WEST SUSSEX COUNTY COUNCIL CONSULTATION

TO:	Arun District Council FAO: Michael Eastham
FROM:	Stephen Gee Highways, WSCC
DATE:	27/11/18
LOCATION:	Land east of, Tye Lane, Walberton
SUBJECT:	WA/95/18/RES Approval of reserved matters following outline consent WA/44/17/OUT for the erection of 175 No. dwellings, car parking including garages, internal access roads, footpaths, parking & circulation areas, hard & soft landscaping, allotments, play areas/equipment & community orchard & other associated infrastructure & engineering works. This application may affect the character & appearance of the Walberton Village Conservation Area.
DATE OF SITE VISIT:	
RECOMMENDATION:	☐ Advice ☒ Objection ☐ Modification ☐ No Objection ☒ More Information ☐ Refusal
S106 CONTRIBUTION TOTAL:	£ See below for breakdown.

| Rev                                                                                                                                                                                                                  | Date         | By                                 | Description |
|----------------------------------------------------------------------------------------------------------------------------------------------------------------------------------------------------------------------|--------------|------------------------------------|-------------|
| Title                                                                                                                                                                                                                |              | Boundary Design Details<br>Sheet 2 |             |

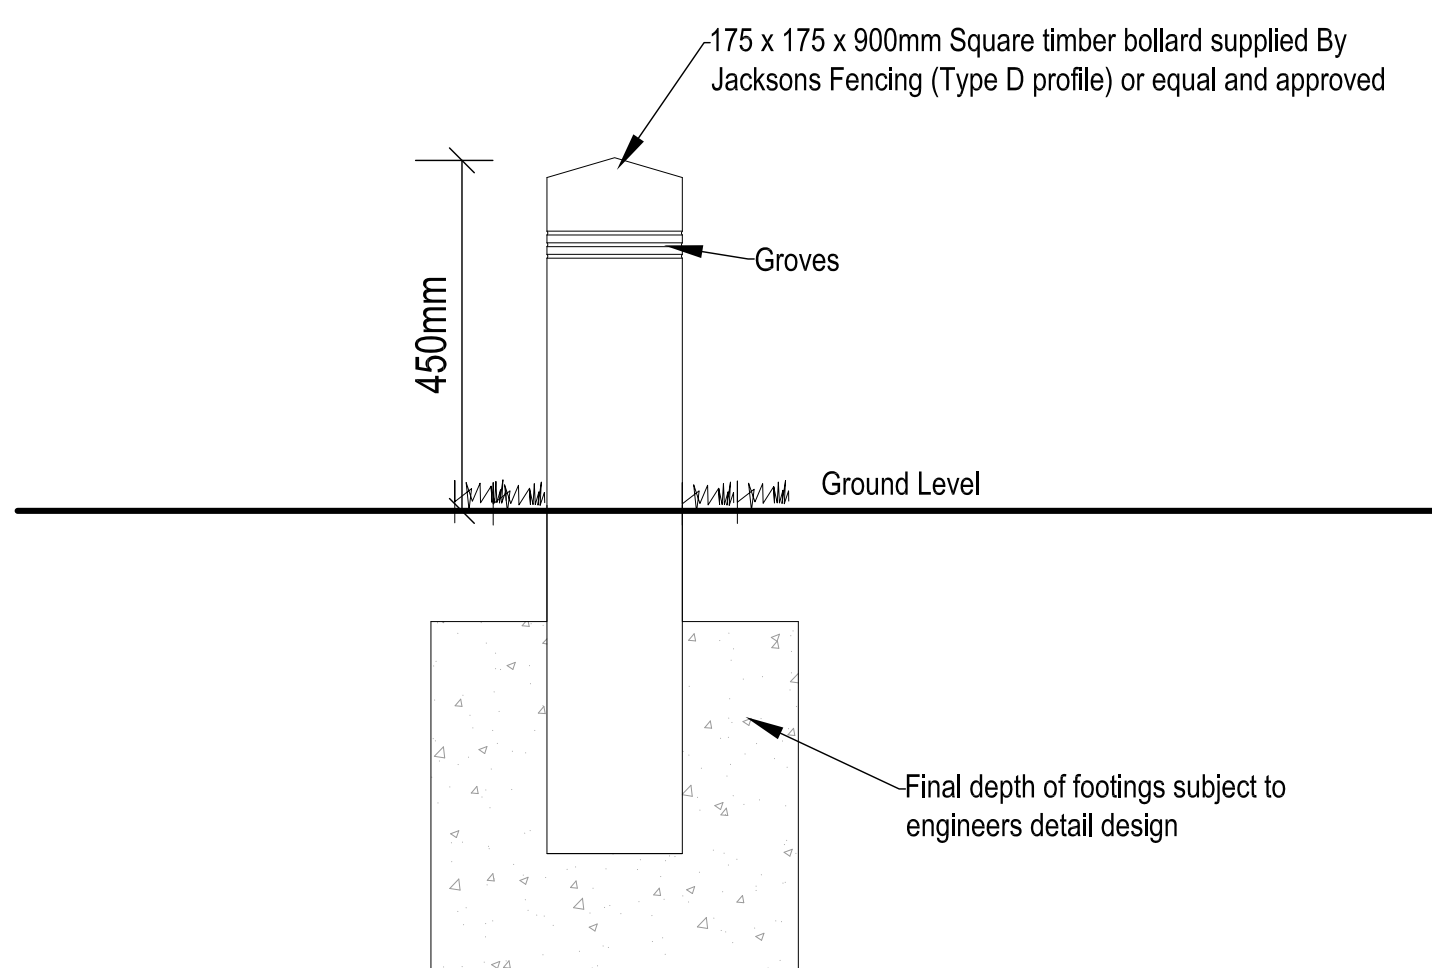
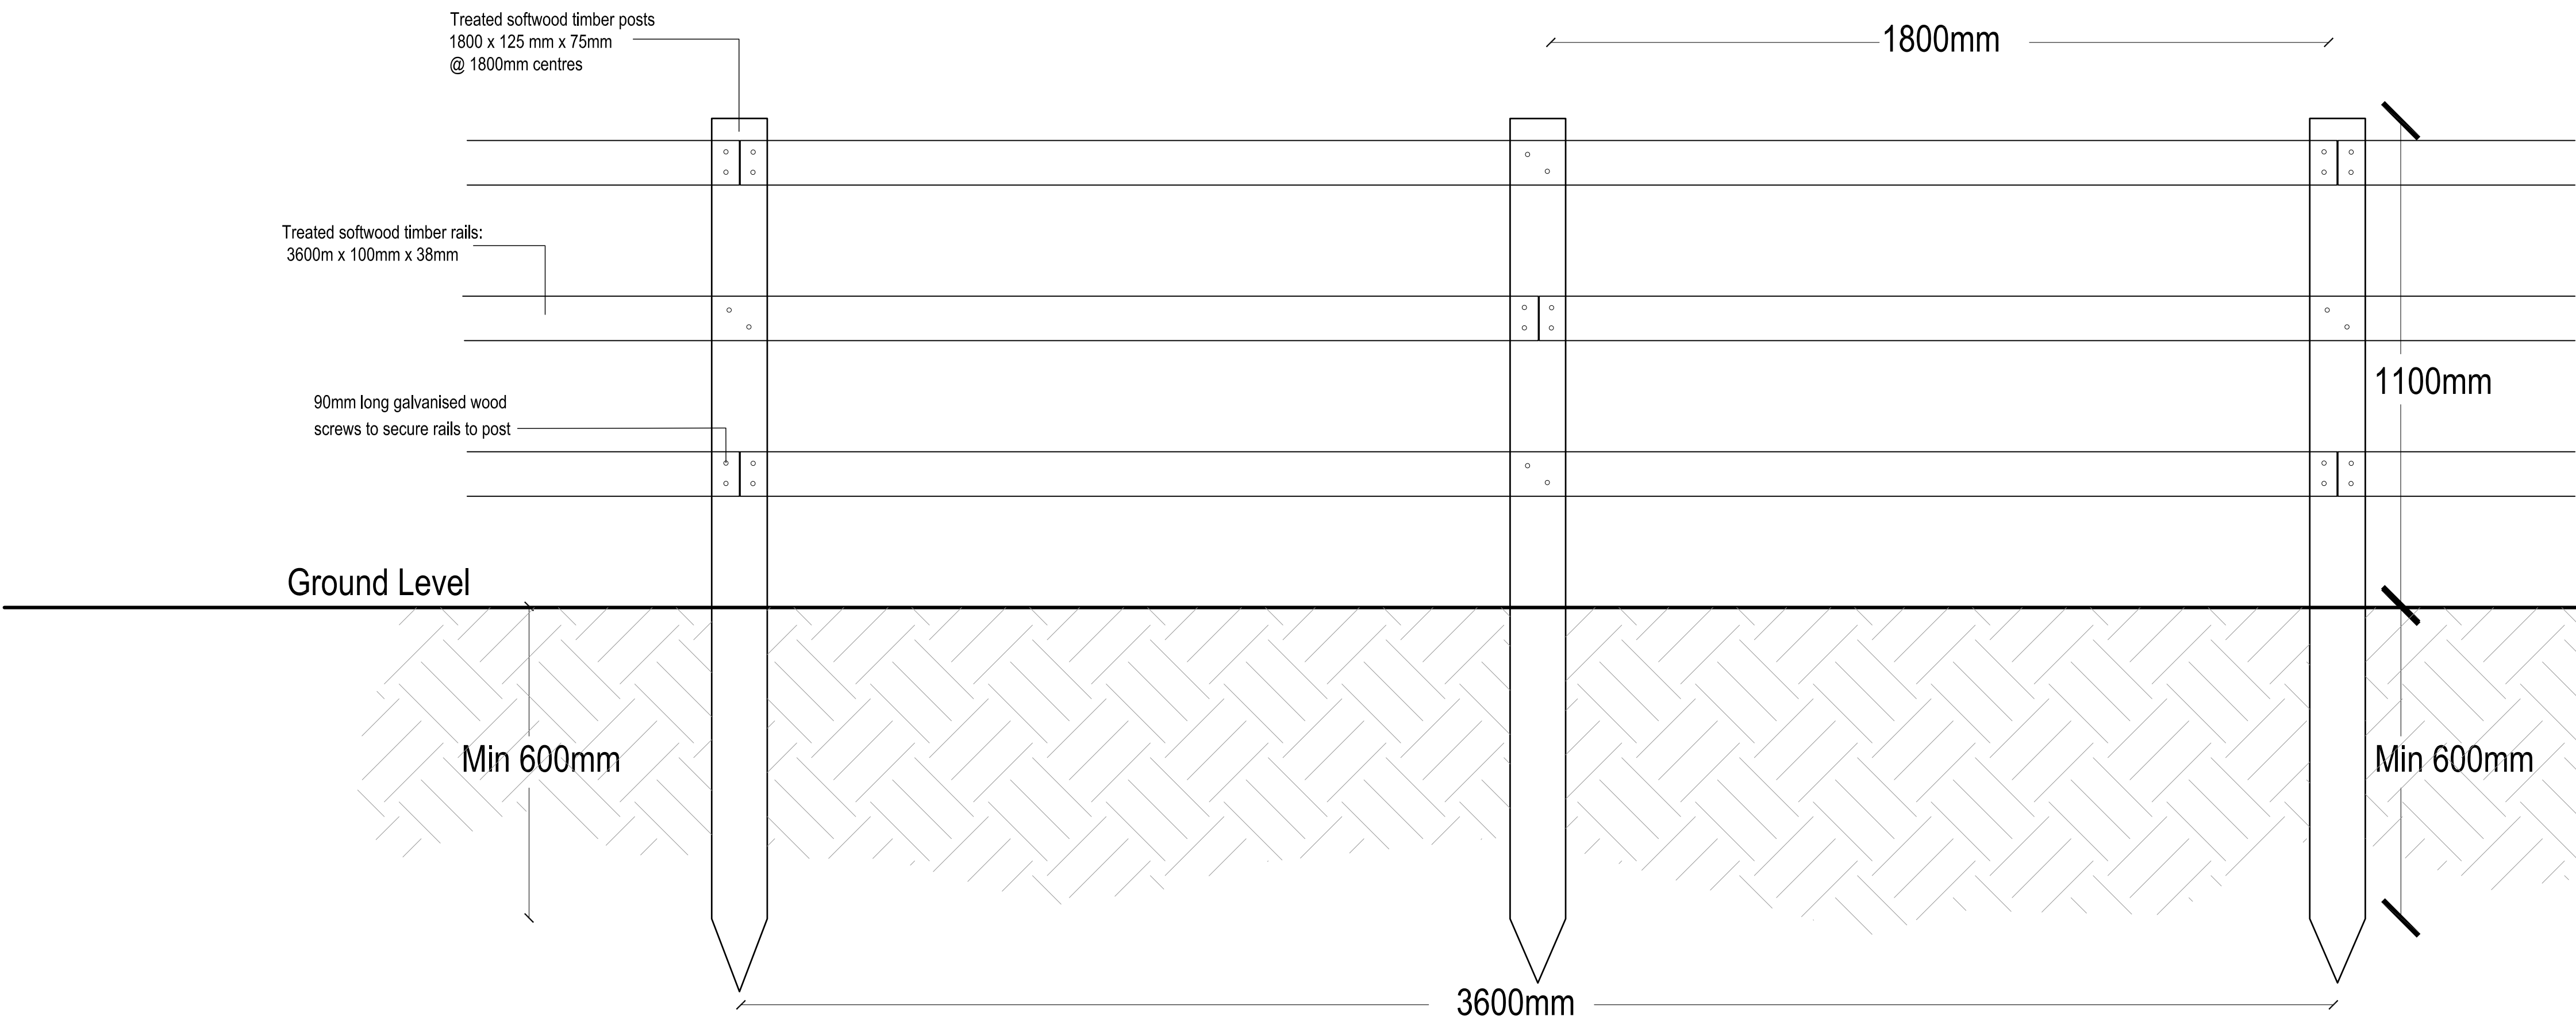
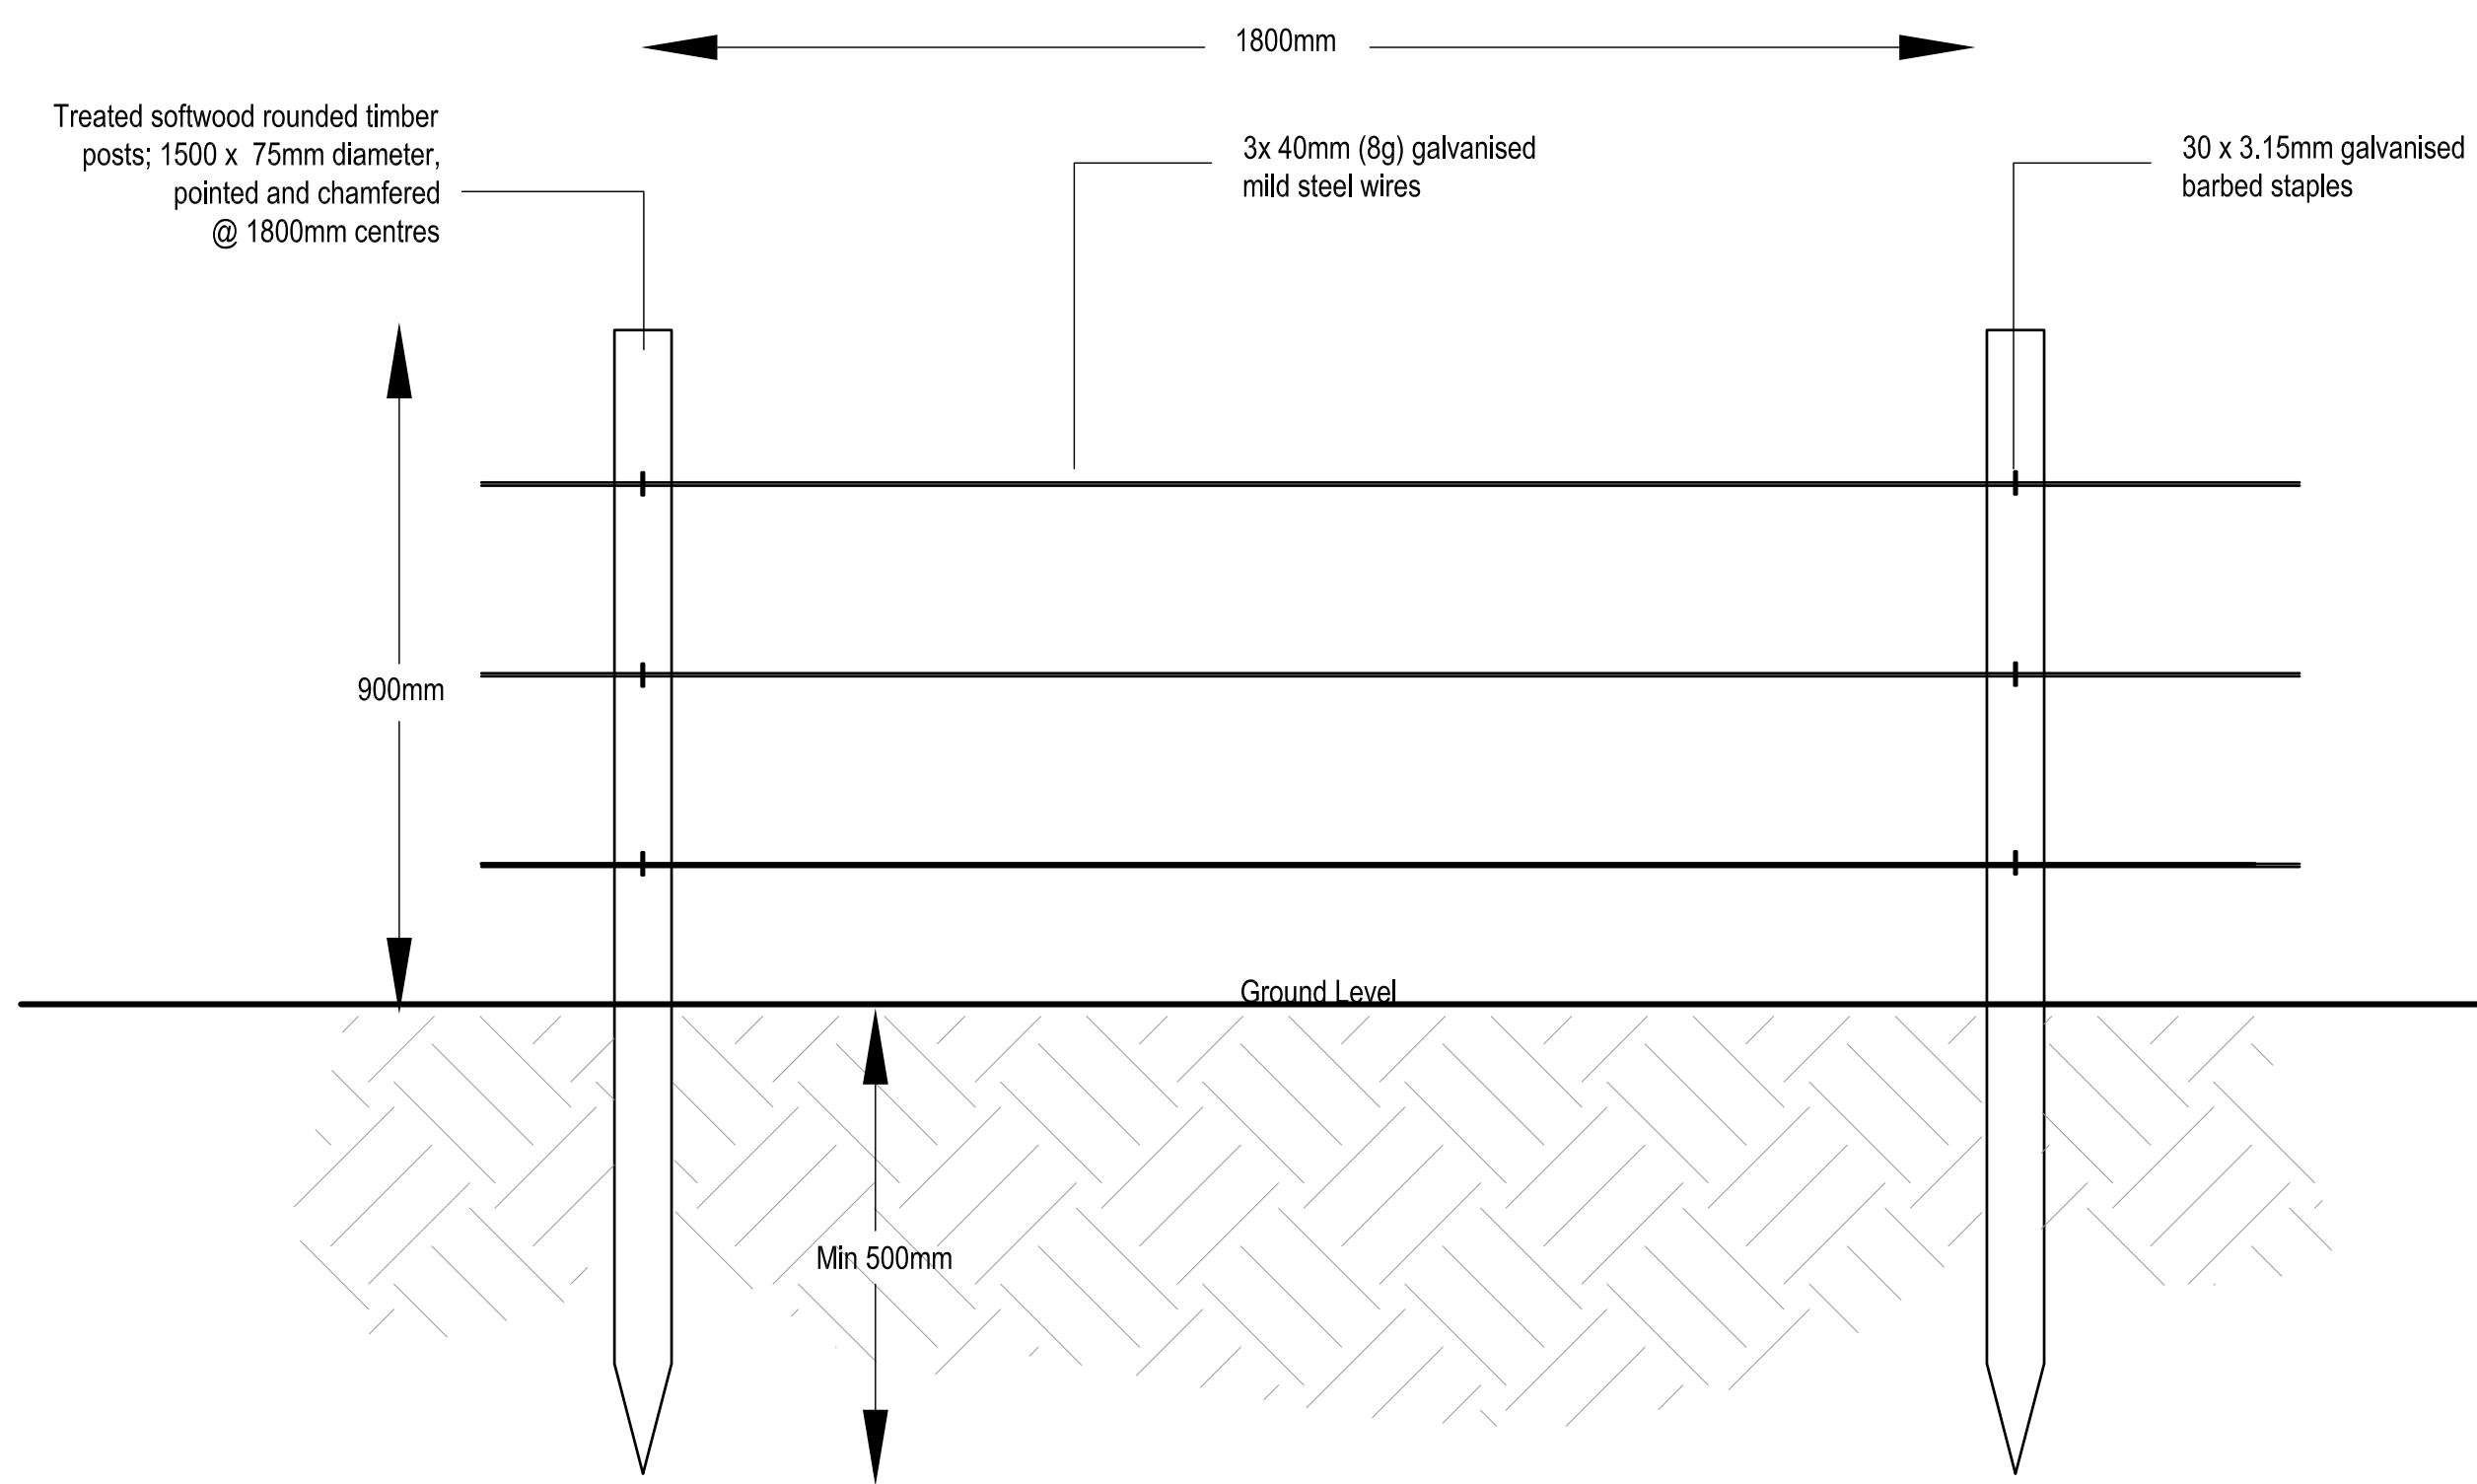
The swept path plan provided appear to show an overhang at the northern drives, when comparing this to the public open space landscape proposals it appears to show the overhang area would have timber bollards of 900mm high placed within the area.

Additional close up detail of the tracking should be provided to confirm if this is not the case, or if so the landscaping proposals amended to allow a refuse vehicle to overhang.
